POST EPC MEMORANDUM

TO: CABQ Development Facilitation Team (DFT)
FROM: William Steele, Senior Planner
DATE: 03/14/2025
RE: PR-2020-004098, SI-2024-01284 – Site Plan – EPC

SI-2024-01284 – Site Plan – EPC

NO.				DATE		BY		REVISIONS		JOB NO.	
										2024.050.4	
										08-2024	
										SHEET	
										CU101

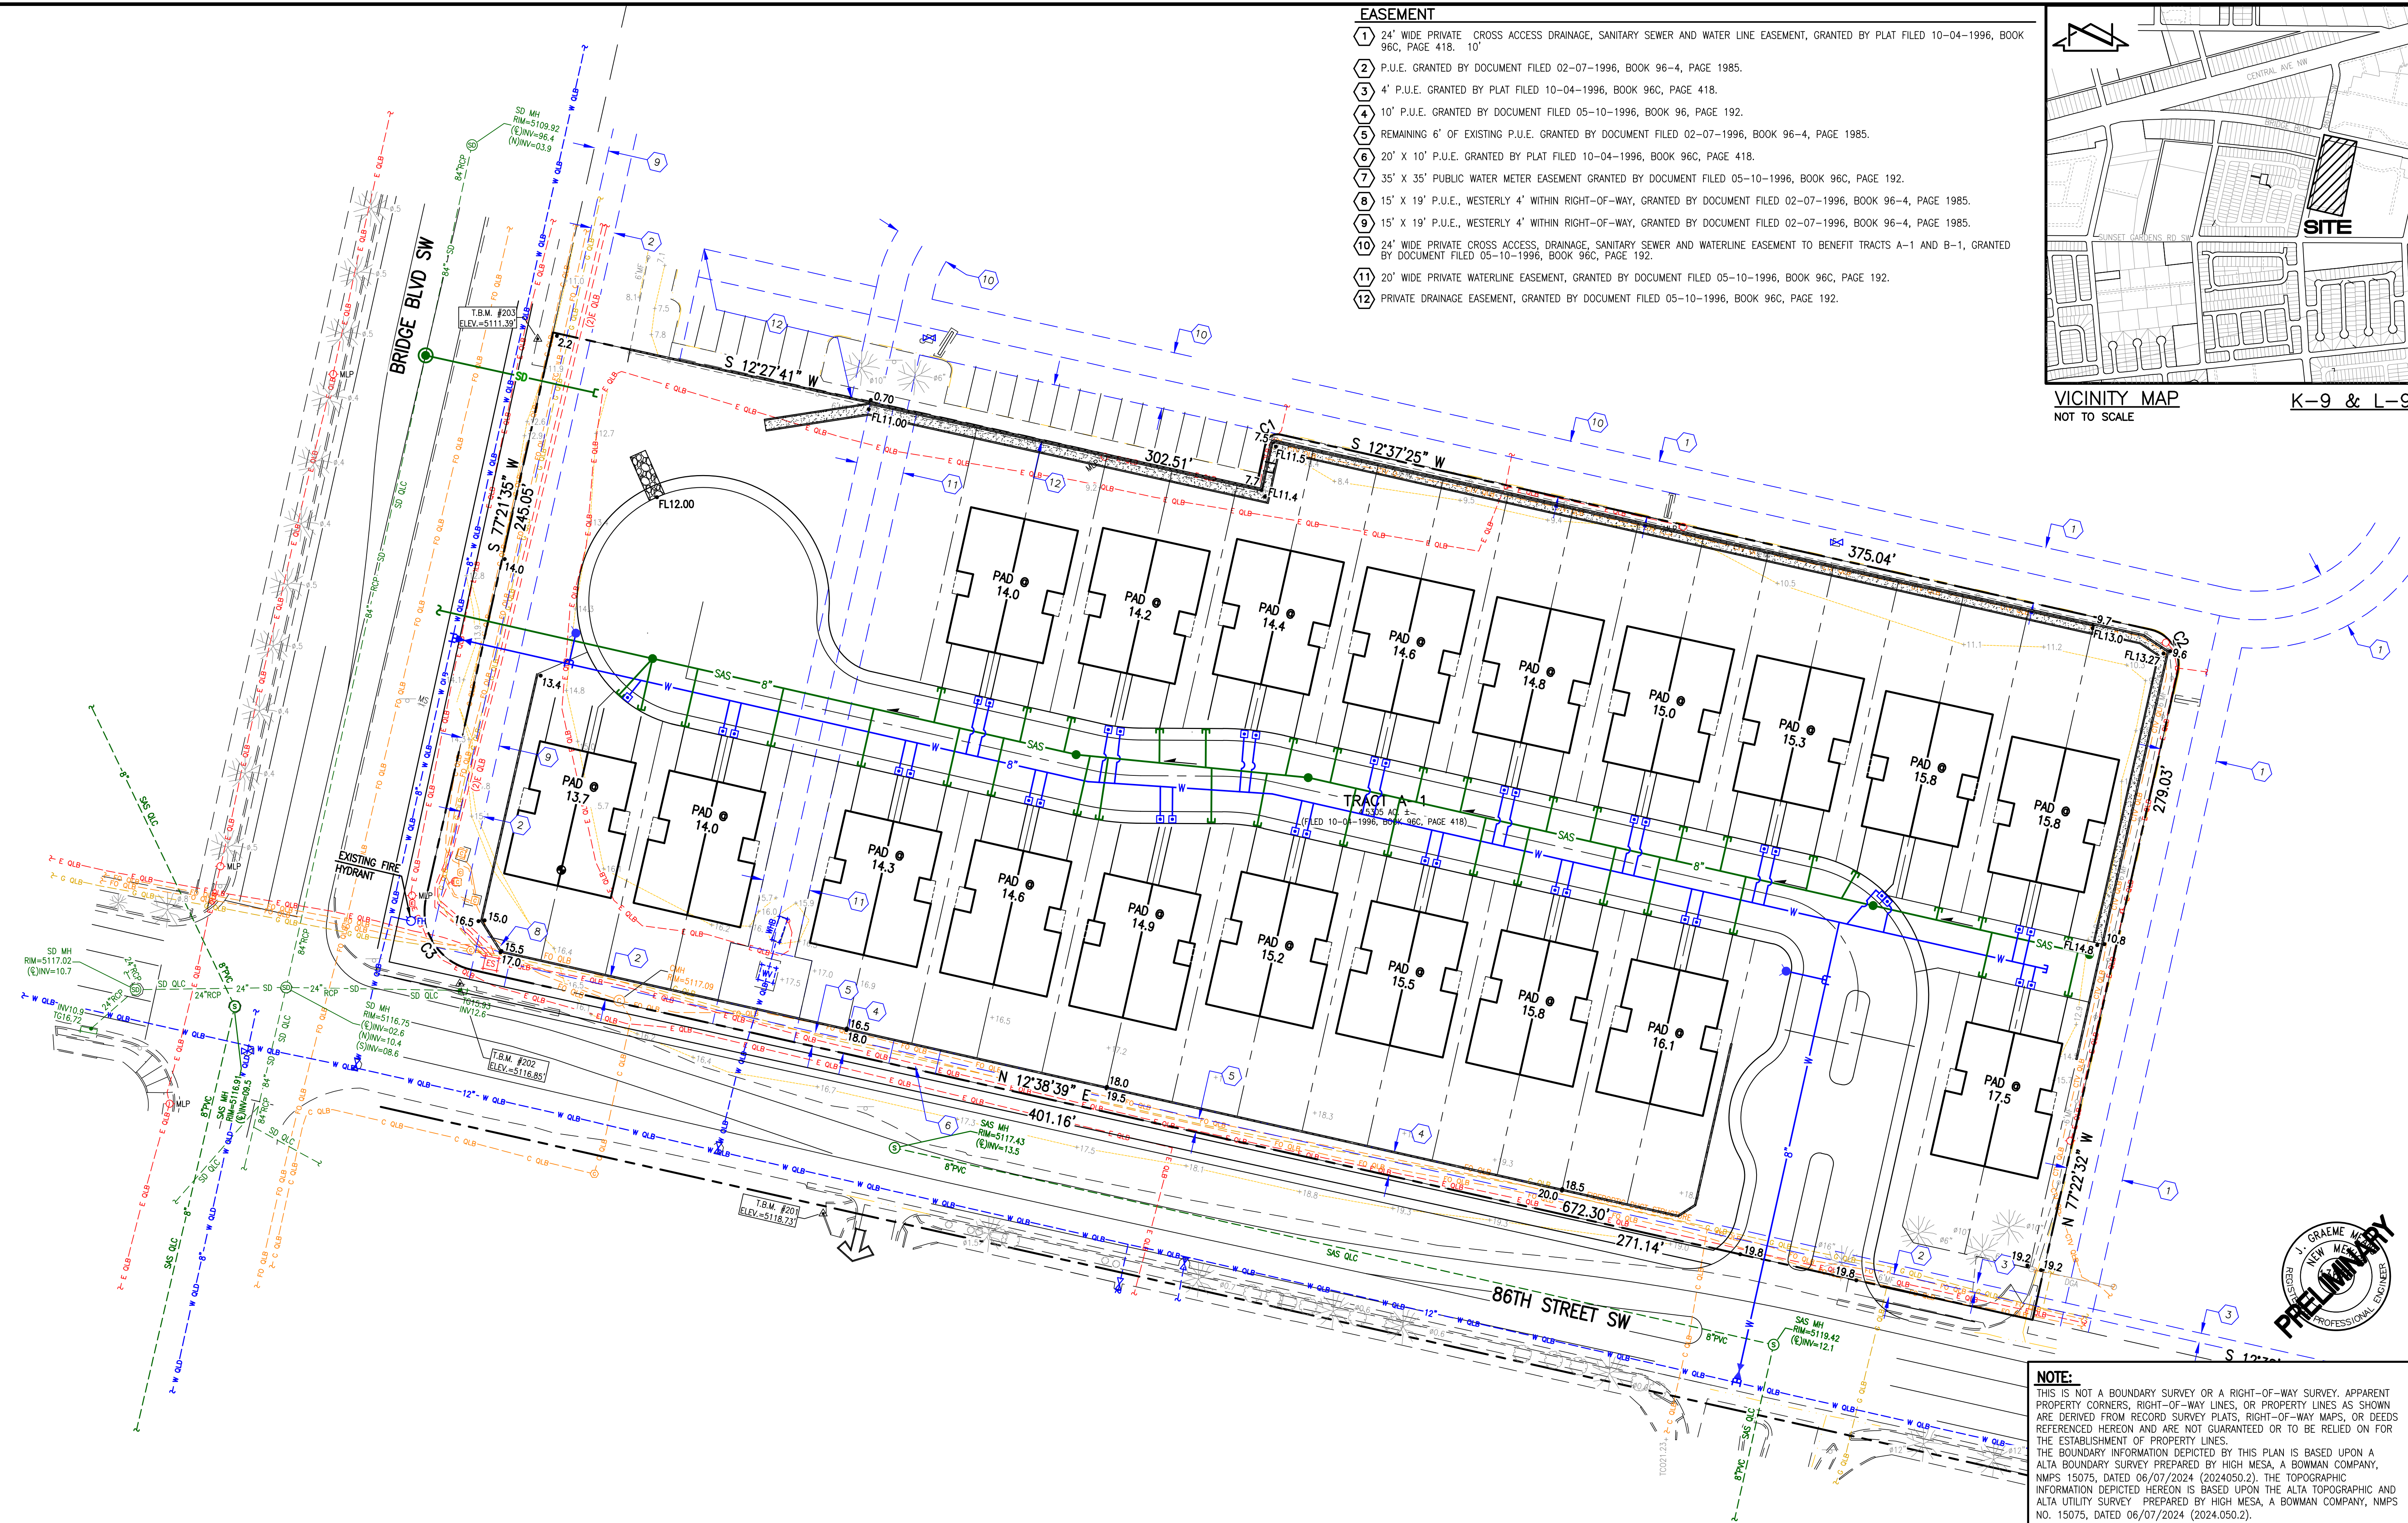
10. Condition 10 (A-B) has been met for Utility Plan (CU101):

- A. The word CONCEPTUAL was removed from the title of the sheet.
- B. The NOT FOR CONSTRUCTION stamp was removed from the sheet.

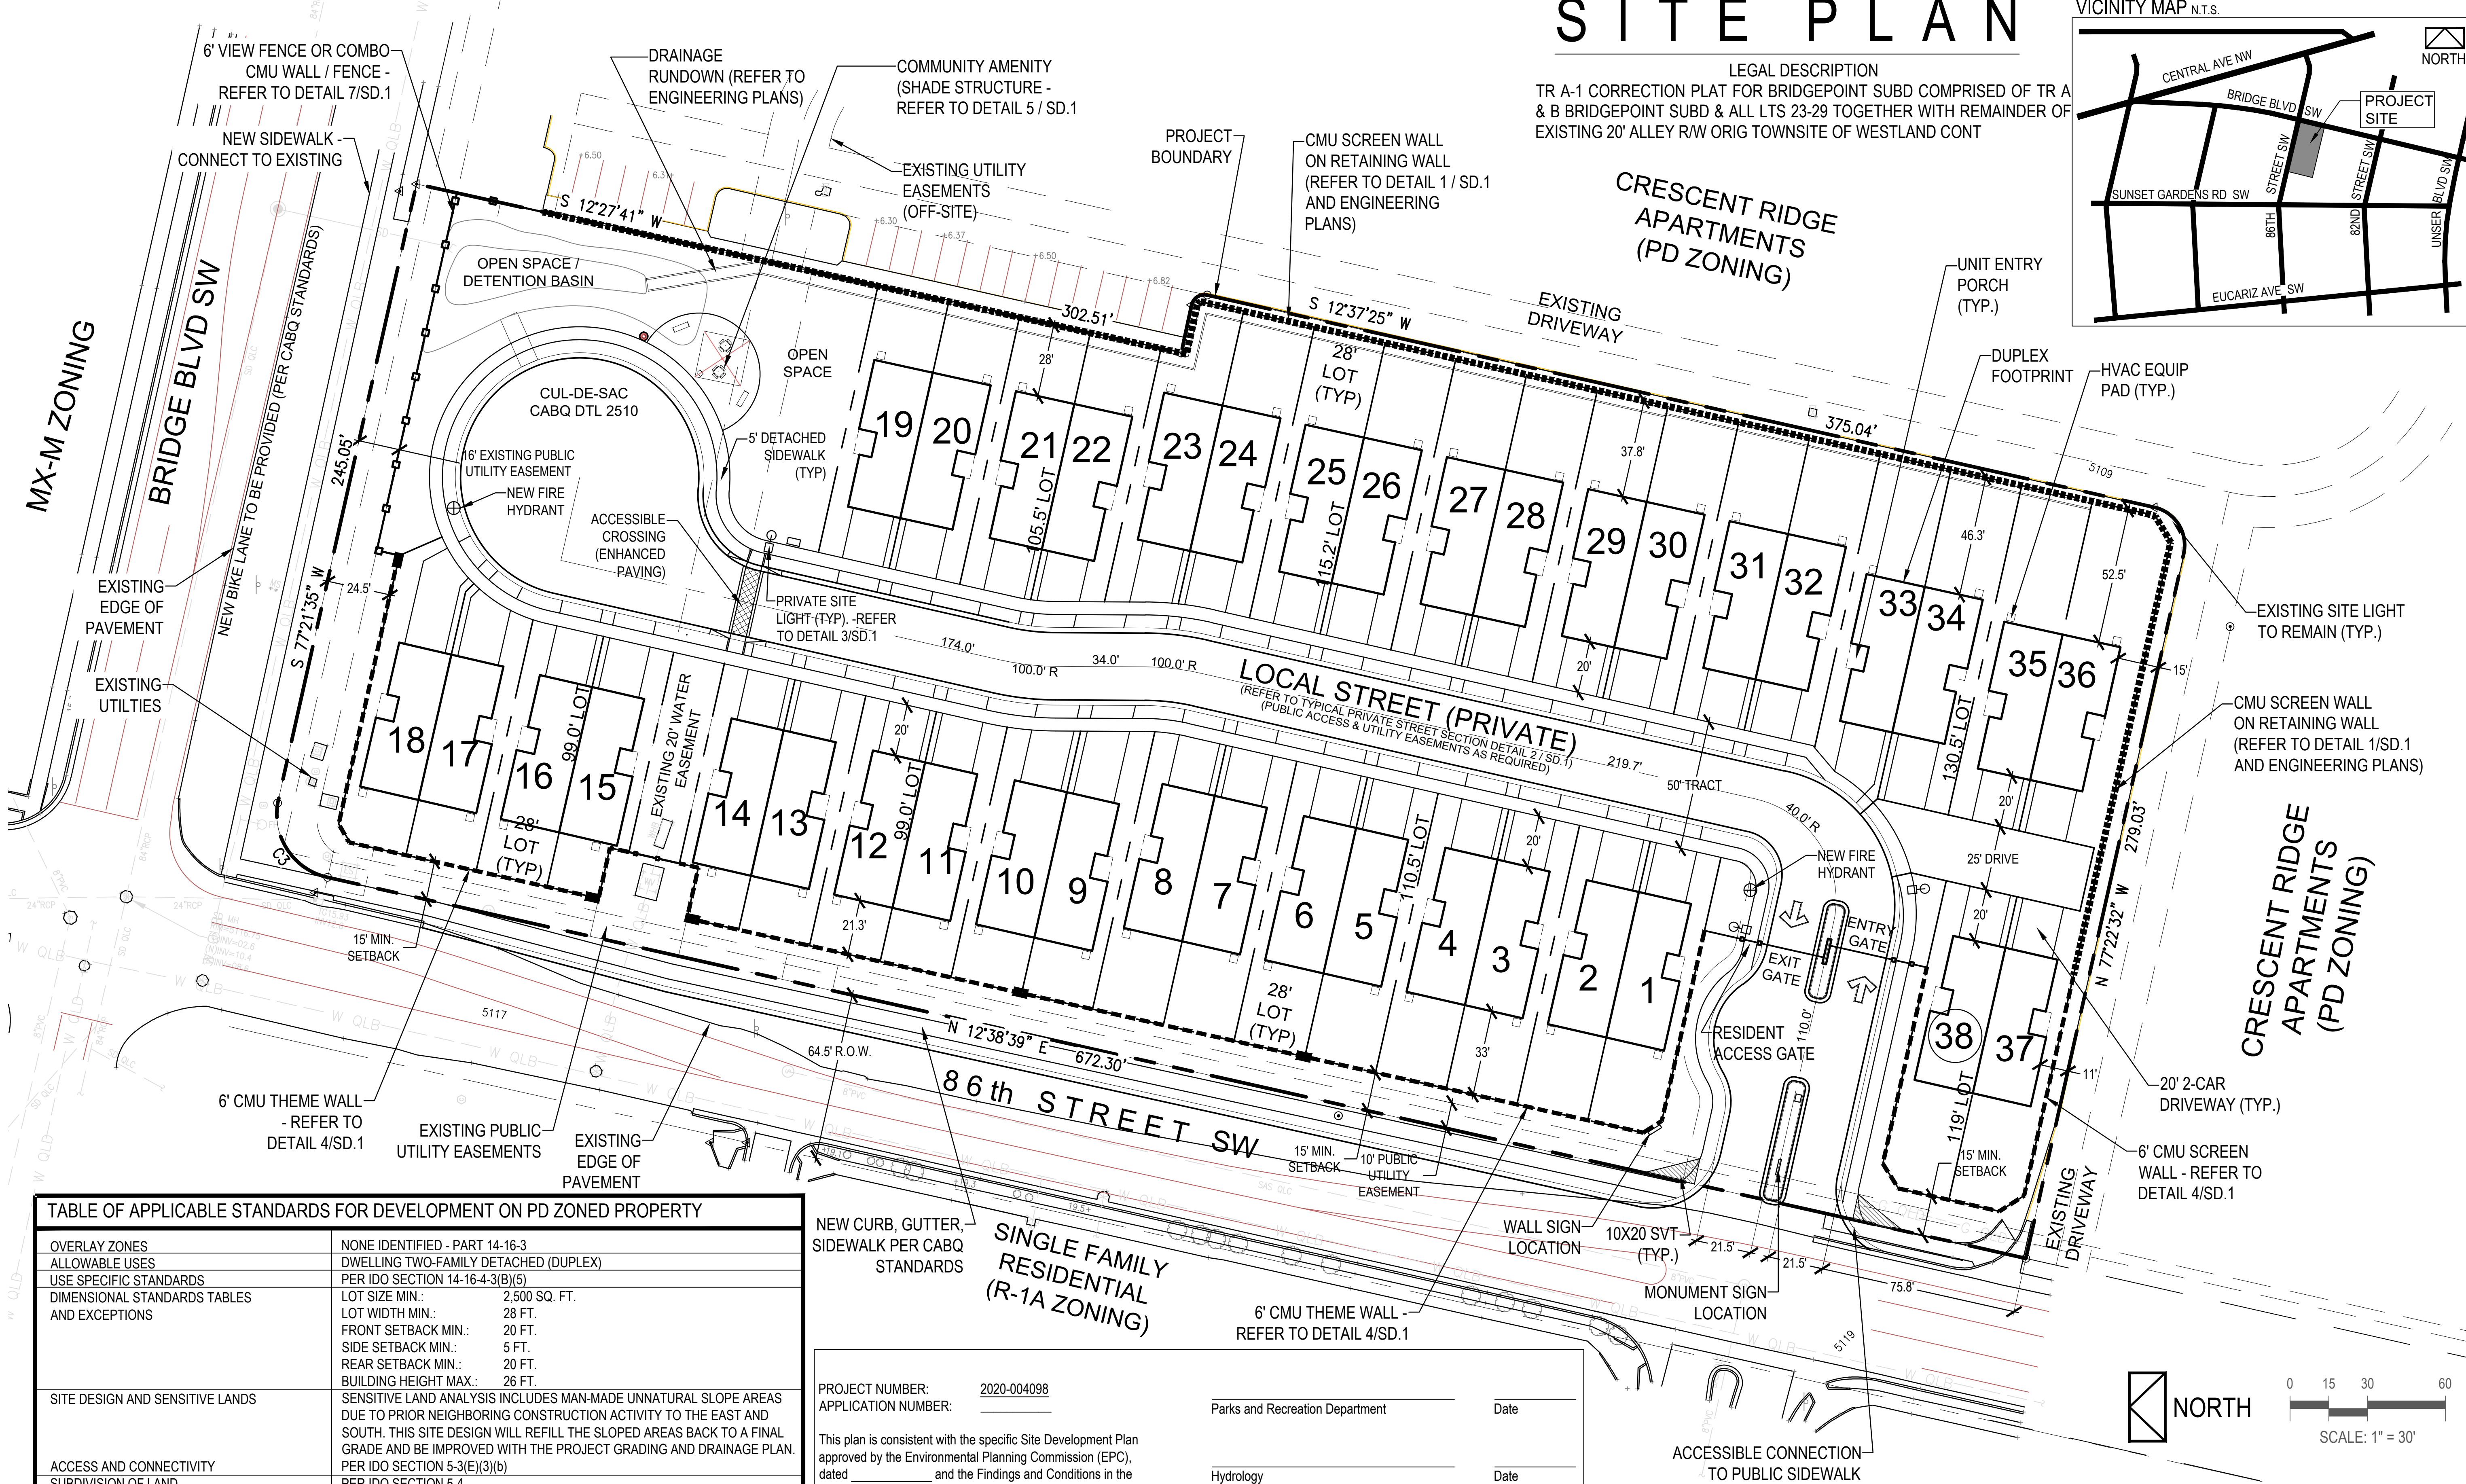
- A. The entry and exit “resident access” gates for residents has been noted on the site plan.
- B. The existing zoning for parcel across Bridge Blvd NW has been corrected to MX-M.
- C. The description “Major Collector” has been removed from both roadways.
- D. The trellis on the site plan was renamed to “shade structure.”
- E. Colored utilities lines were changed to black or grey to not dominate the site plan drawing.
- F. Table of Applicable Standards:
 - 1. OUTDOOR AND SITE LIGHTING description has been edited and now reads: “15-FT. PREFINISHED OR PAINTED STEEL TUBE LIGHT POLES AS INDICATED AND REMAINDER PER IDO SECTION 5-8.”
 - 2. LANDSCAPING, BUFFERING, AND SCREENING description has been revised and now states, “STREET TREES PER STREET TREE ORD. 6-6-2-4, MULCHING PER IDO 5- 6(C)(5)(E) AND PONDING PER CITY STANDARD SPEC., SECT. 1013 AND REMAINING AS INDICATED ON LANDSCAPE PLAN.”

SCALE	AS NOTED
DATE	02/04/24
REVISION	
TITLE	SITE SIGNAGE DETAILS
SHEET

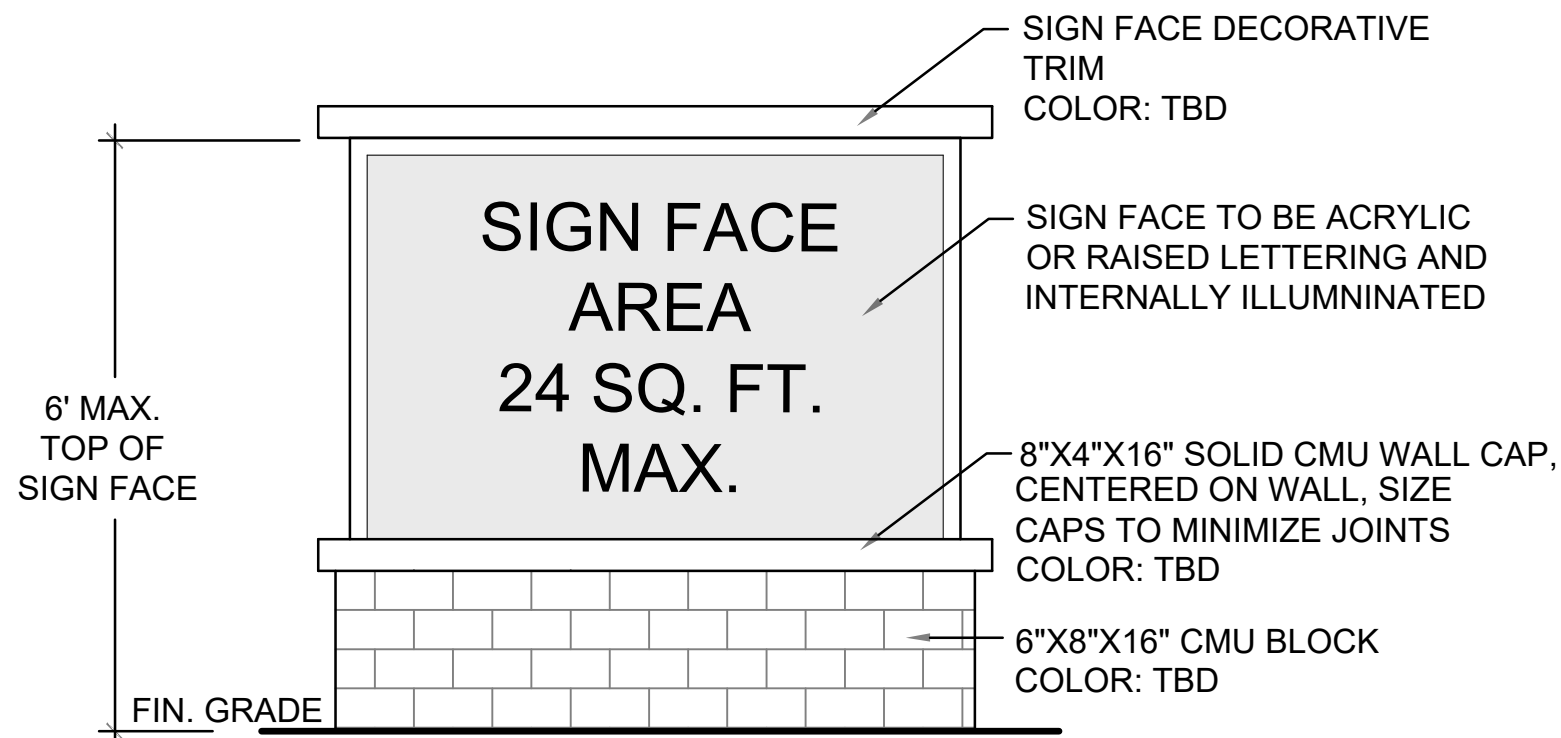
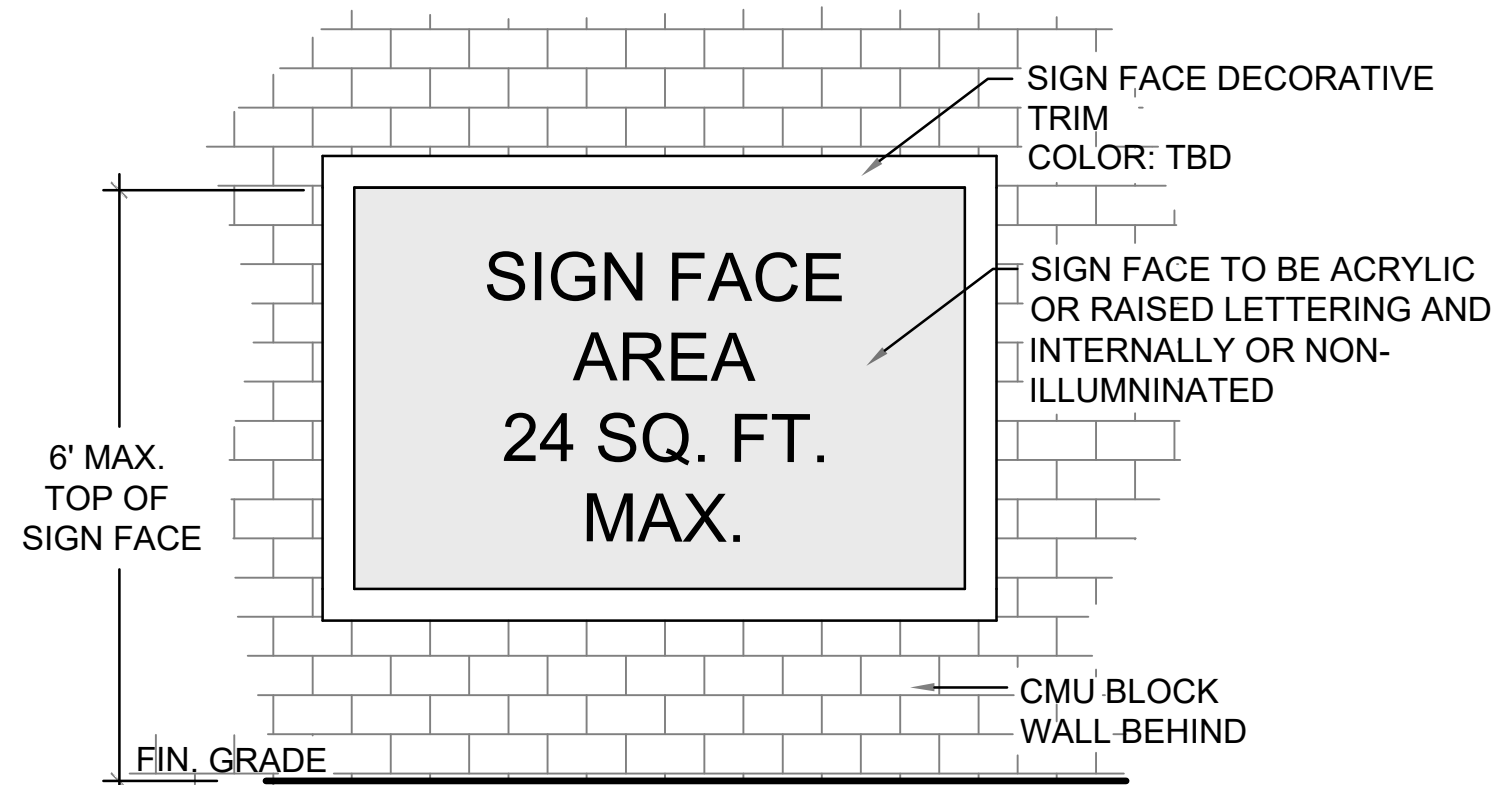
- A. The location of the monument sign and wall sign is identified on the site plan sheet.
- B. Signage details illustrating the signage area are included in the drawing set on Site Signage Details sheet SD.02.
